From: Nicola Spencer
Sent: 14 March 2019 16:15
To: Karen Parsons
Subject: FW: BR/326/18/PL - The Royal Hotel, The Esplanade, Bognor Regis

Third floor

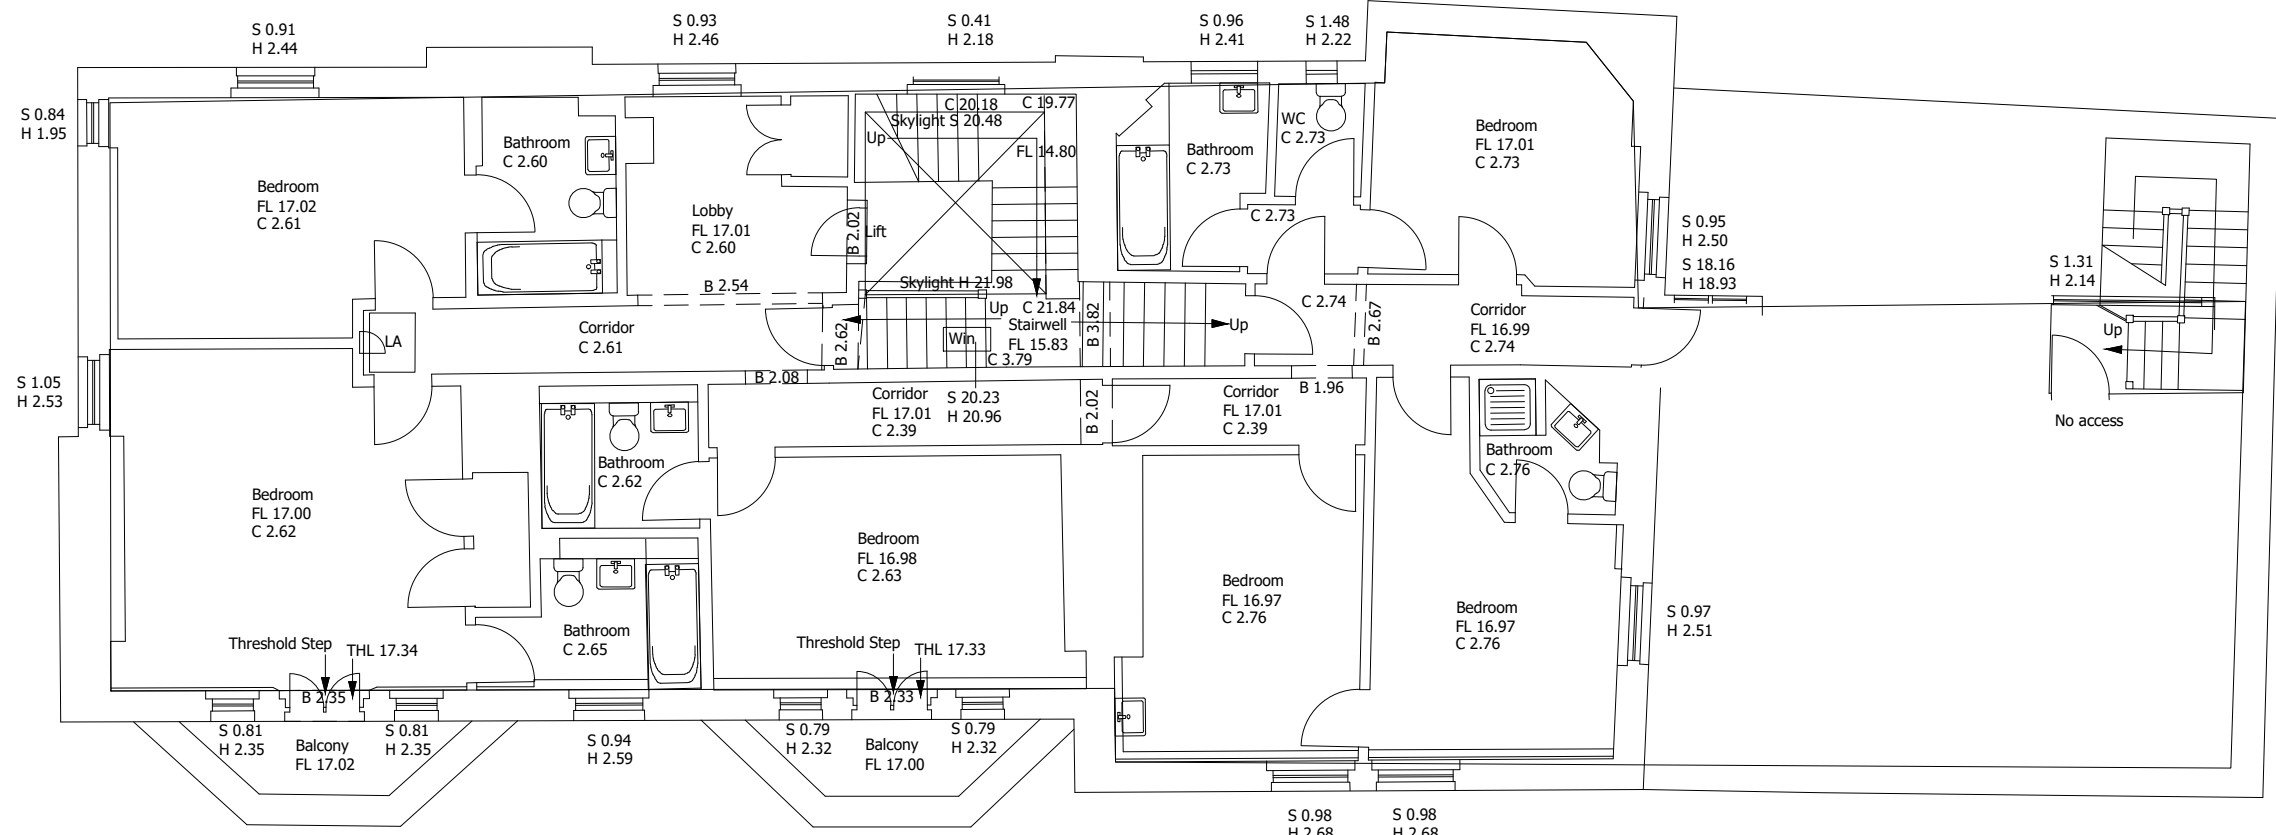
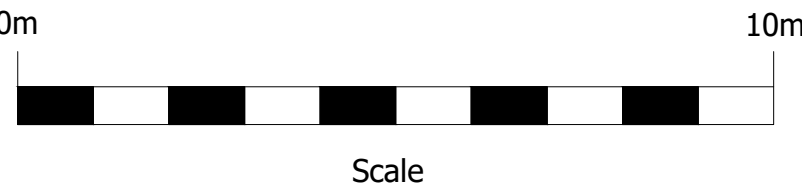
One thing he mentioned (and was going to be in his response) was a discrepancy with the plans regarding the dormers on the flank roof planes of the main roof. I think from memory that there are some elevations and possibly the upper floor plan where one or both of these are not shown. I also think he had said that some of the drawings have not made it onto our website. I can't compare to the file at present as Martyn has it but I can't see a third floor plan or an east elevation on the plans we have uploaded. If these are a thing, can you email to me and I'll fix the public viewer. Please also have a look into the dormer issue.

There was such a query re floor plan and elevations at validation stage and we submitted revised plans on 3 Jan 19 and I will forward a copy of the email in a moment. Meanwhile please see 3rd floor and the north elevation which were changed to reconcile an inconsistency at that time. Perhaps this is what Martyn is remembering. There is no east elevation, the other elevations cover all aspects as there is another building to the east.
